Arun District Council
Arun Civic Centre
Maltravers Road
Littlehampton
West Sussex BN17 5LF
Planning & Building Control General Enquiries
Tel: (01903) 737756 Fax: (01903) 730442
Dx: 57406 Littlehampton
Minicom: 01903 732765
e-mail: planning@arun.gov.uk
website: www.arun.gov.uk/planning

Application No: EP/47/21/HH
Site Address: West House South Strand East Preston BN16 1PN
Description of works: Erection of second floor addition, part single storey side, part two storey front, side and rear extensions and alterations to fenestration/openings

Thank you for your internet representation made on 15th May 2021 which has been recorded as an objection with the comments as follows:

**W ELEV**

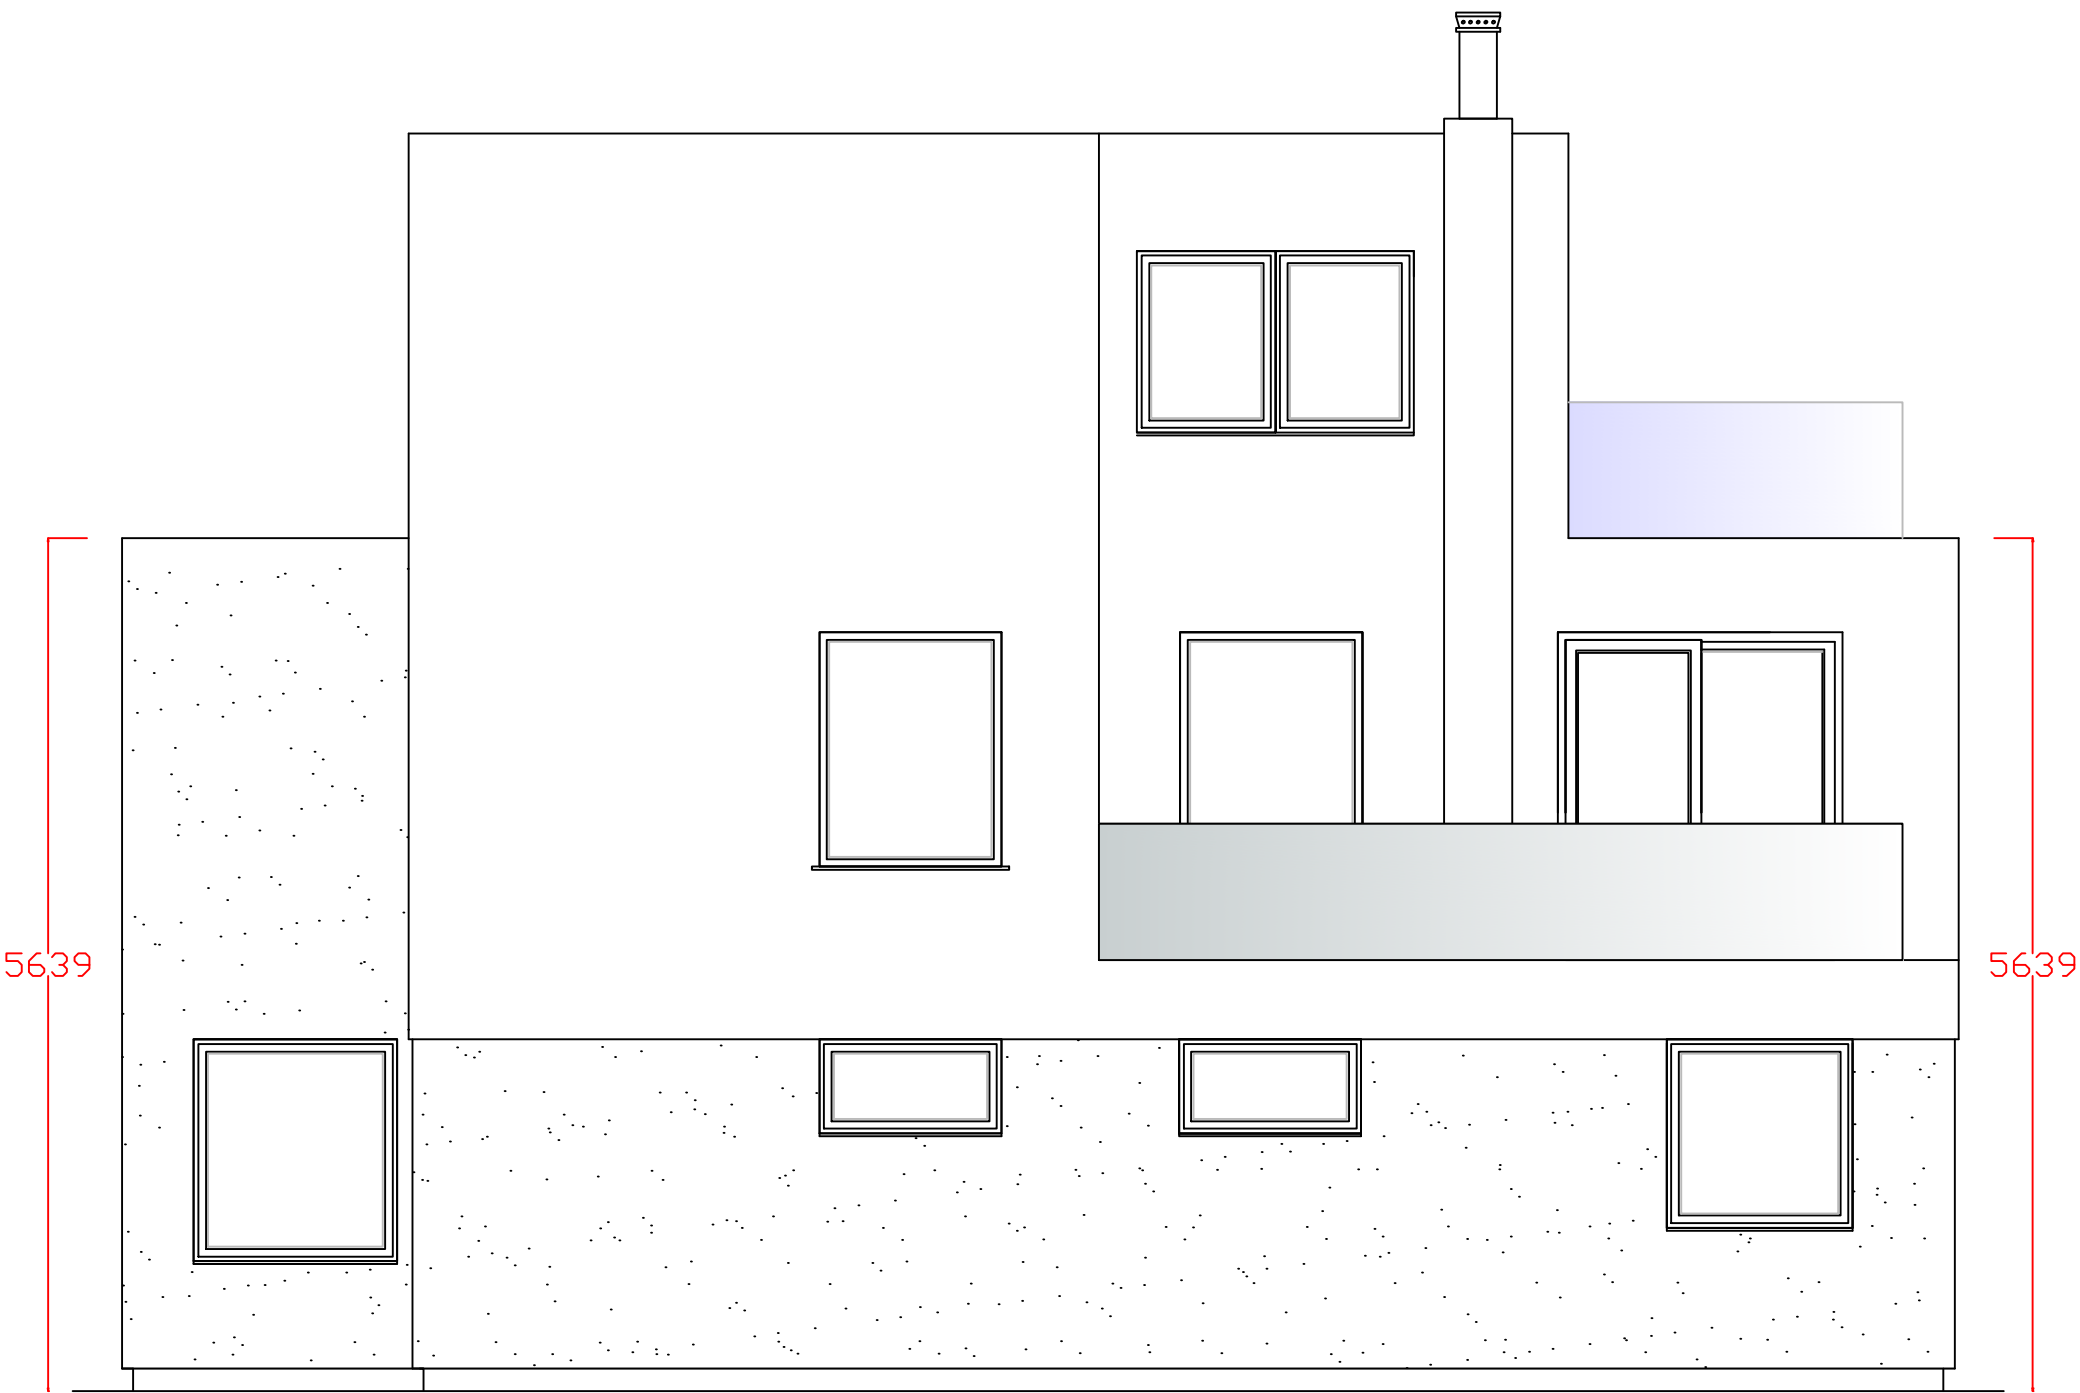
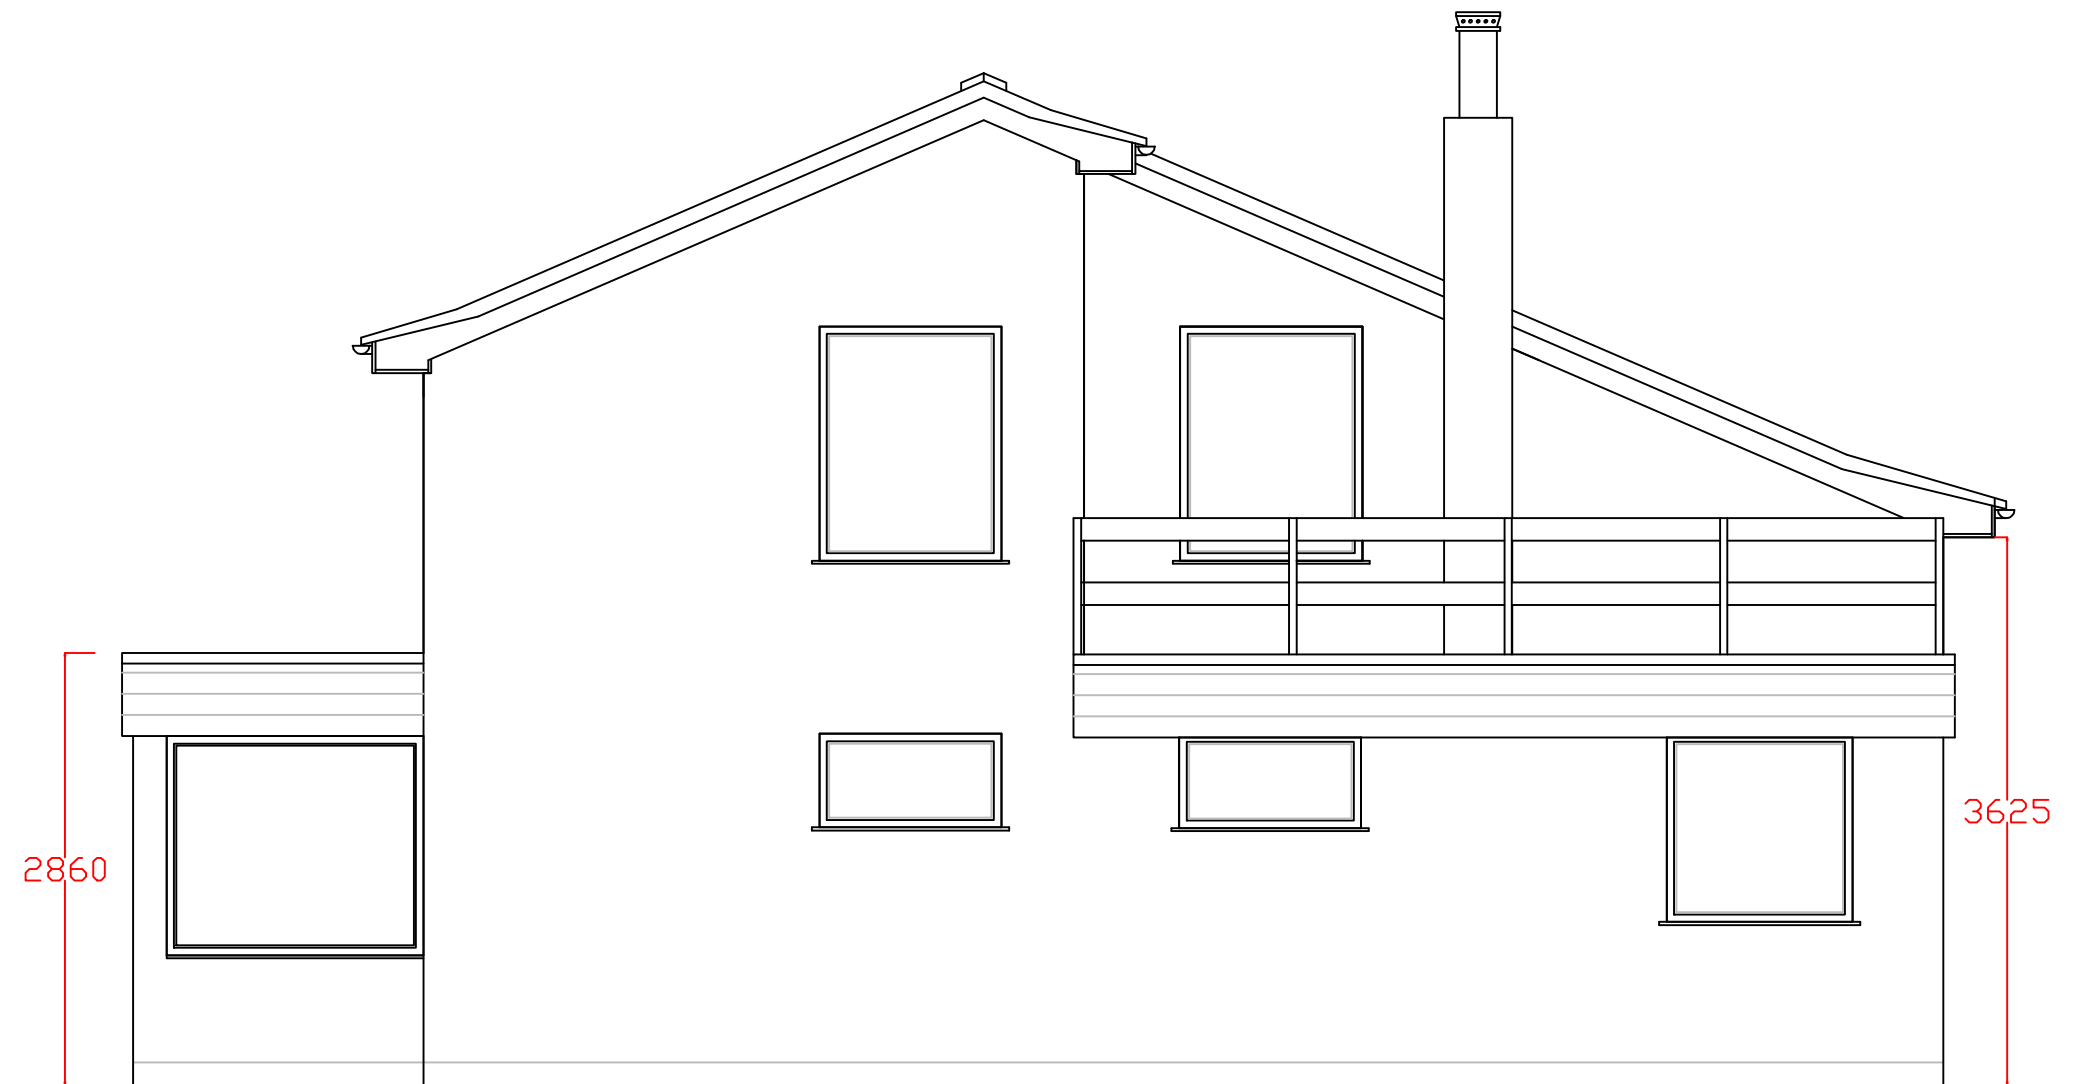
- 3) Loss of privacy from overlooking; West House has first floor west facing windows and a balcony that have limited views over properties to the west due their height. The second story extension will give them clear views into all aspects of the properties to the West of them, particularly as the second floor is to be a sitting room.
